**WELWYN HATFIELD BOROUGH COUNCIL
ASSISTANT DIRECTOR (PLANNING)**

DELEGATED APPLICATION

Application No: 6/2023/2081/HOUSE
Location: 21 St Josephs Green Welwyn Garden City AL7 4TT
Proposal: Erection of a single storey rear extension and single storey side extension to link up with a garage conversion, solar panels, air condition/ashp unit, new side gate, cycle store and landscaping works
Officer: Mrs Kerrie Charles

Title **Proposed Elevation - Sides**

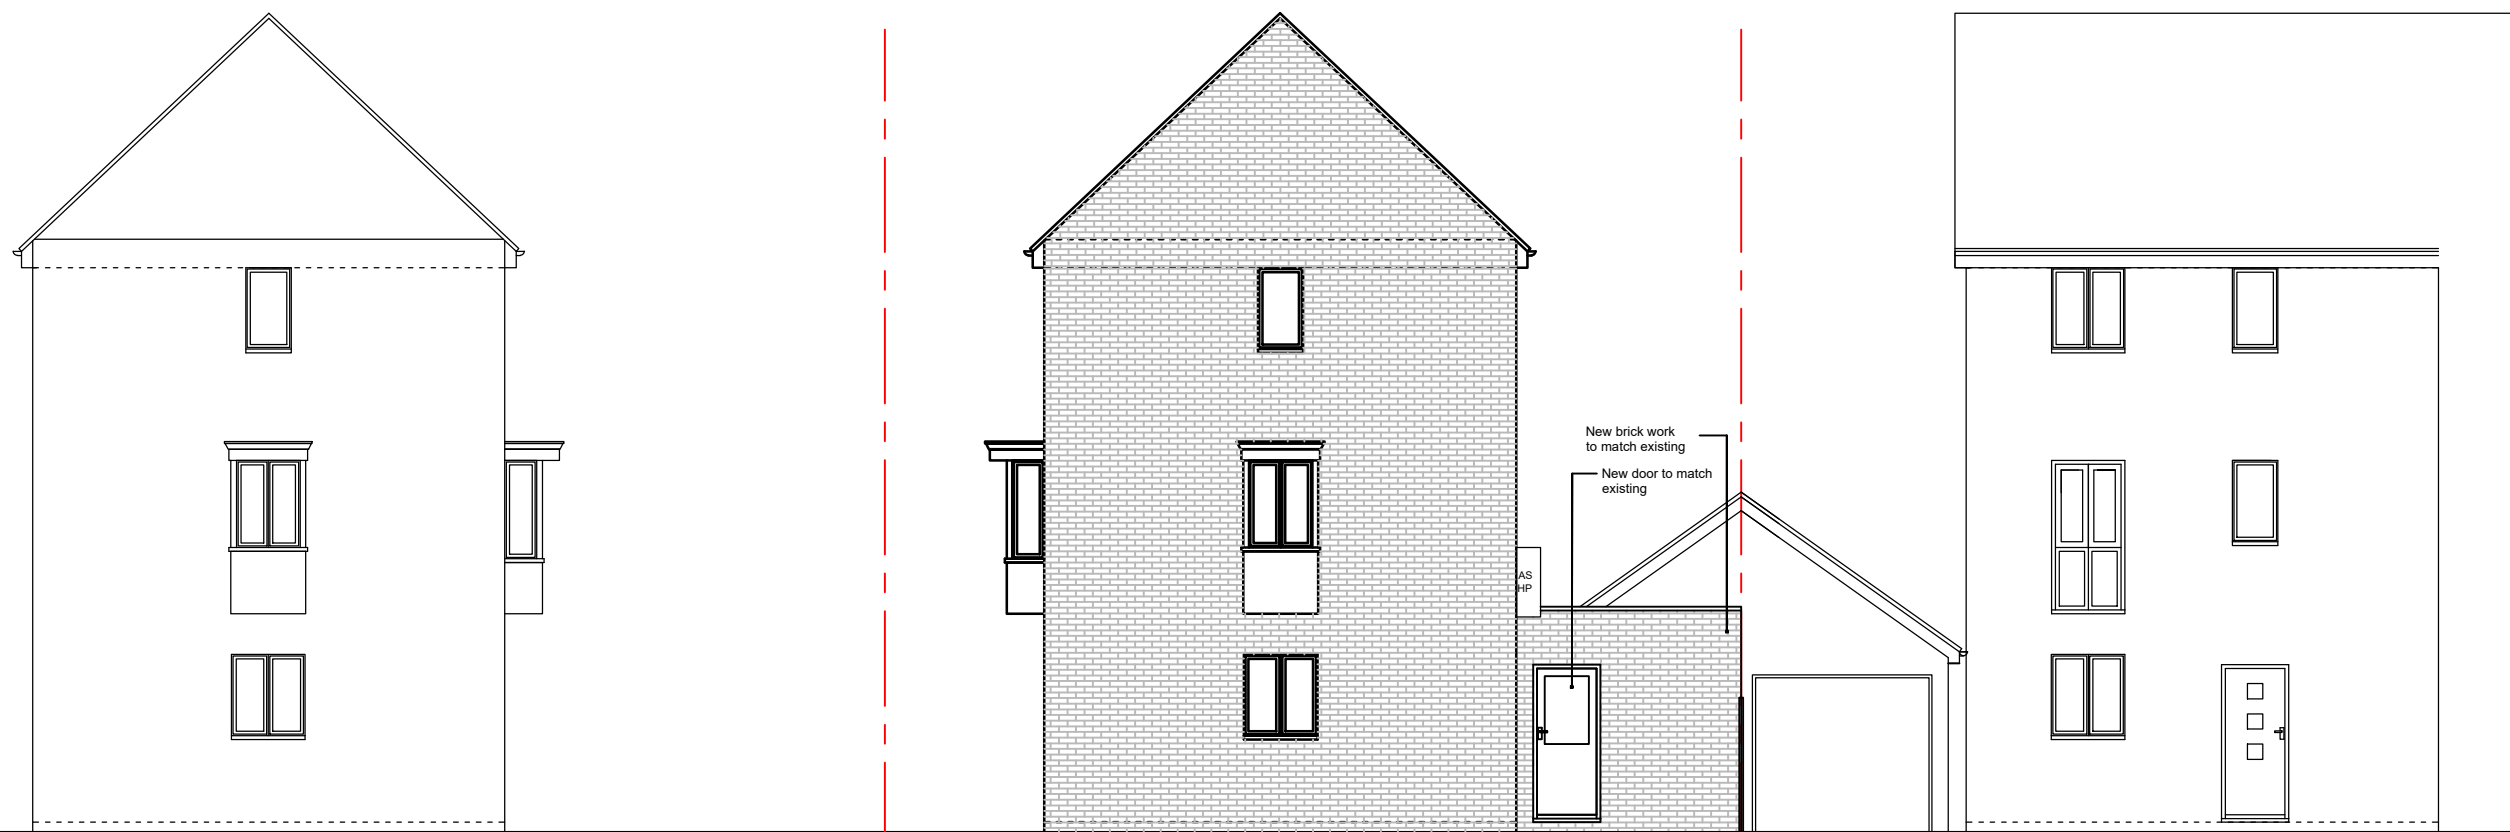
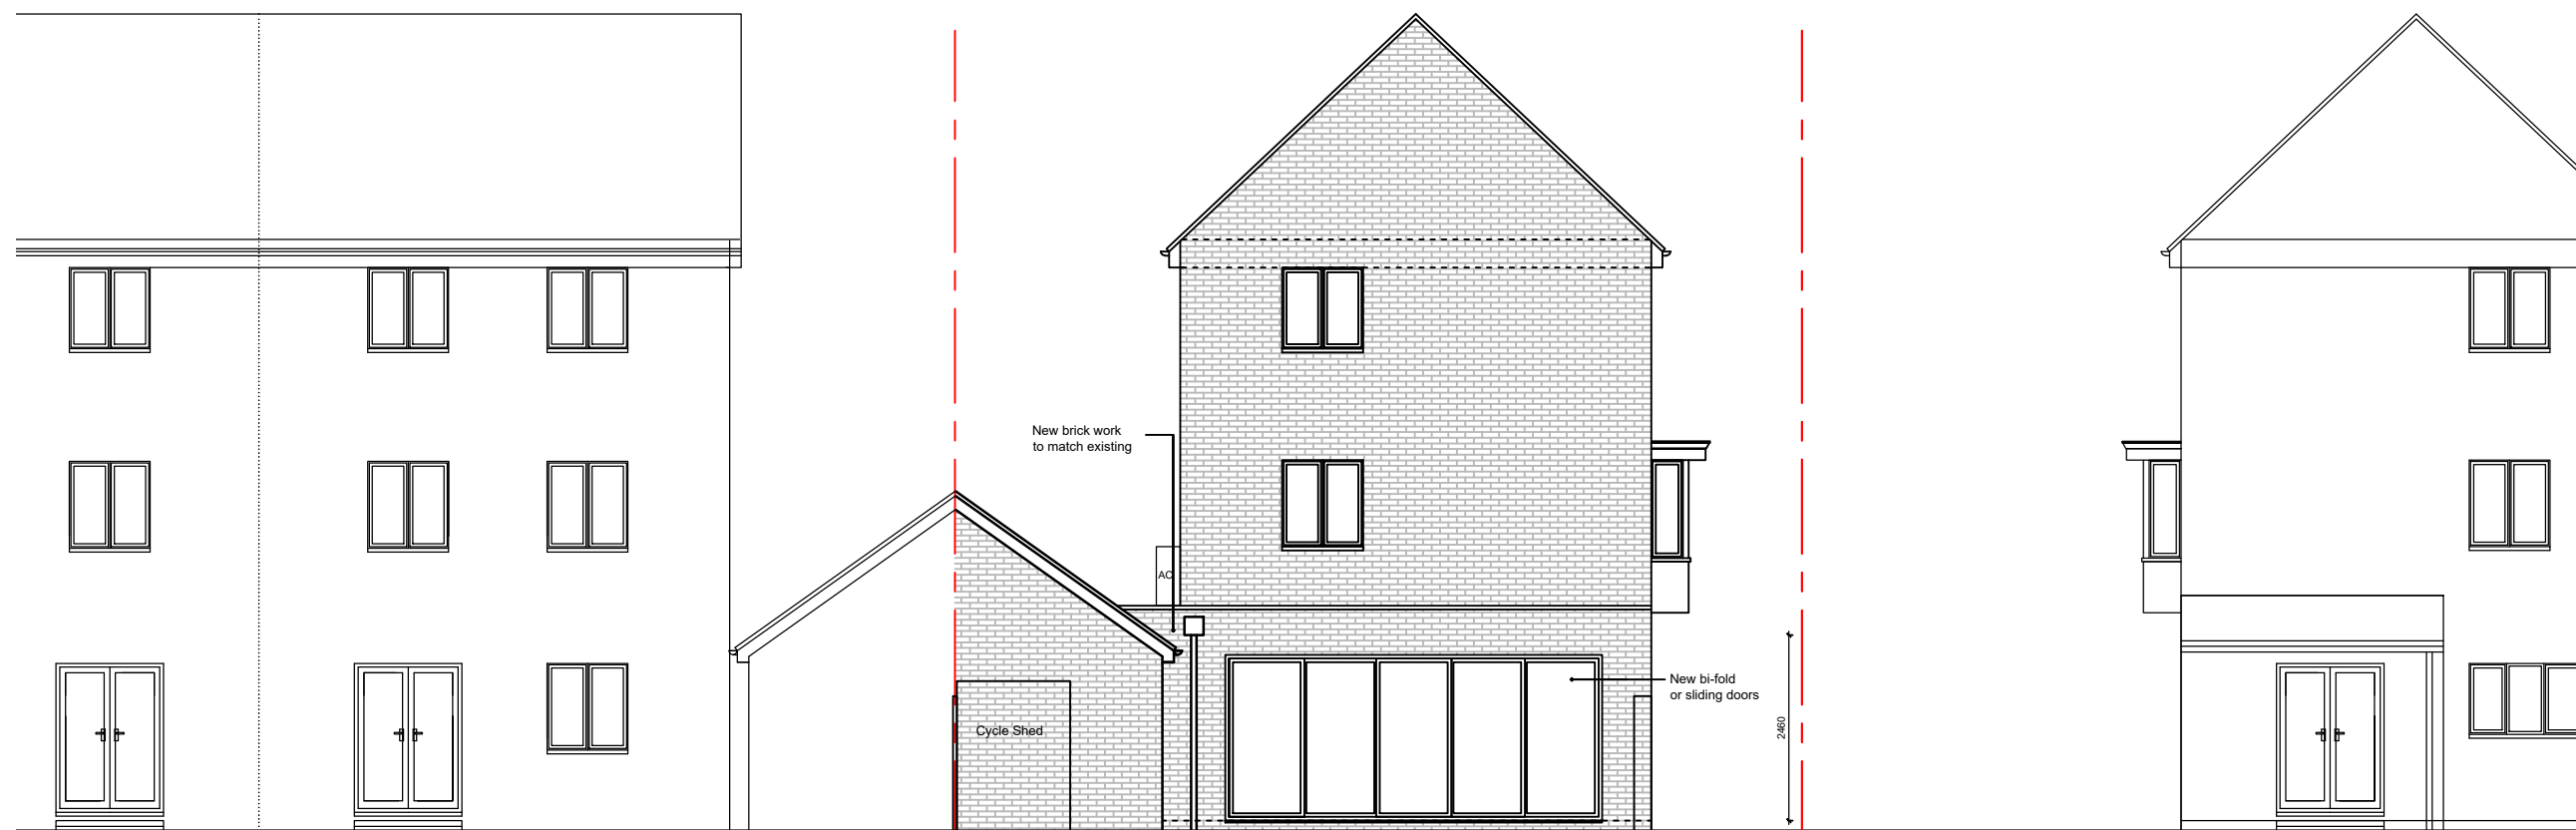
The proposed side extension would be attached to the single storey rear extension and would project outwards, in front of the existing detached garage which adjoins with the property next door. The existing garage provides a sense of symmetry which is aesthetically pleasing. The proposed single storey side extension with a flat roof would obscure parts of the garage, unbalancing the symmetrical appearance. However, it is noted that this would only be visible from specific public vantage points within the street scene, which face directly towards this area of the site. This is because the application dwelling and the adjoining dwelling would largely obscure this part of the site from other viewpoints. In addition, the extension would be built close to the rear building line of the rear elevation of the dwelling and as such it would be considerably set back from the elevation which faces Eddington Crescent. For these reasons, it is considered that this aspect of the proposal would, on balance, be acceptable.

The air conditioning units and air source heat pump would be visible from the road but would be of a modest scale that would not detract from the character of the surrounding area and are therefore considered acceptable.
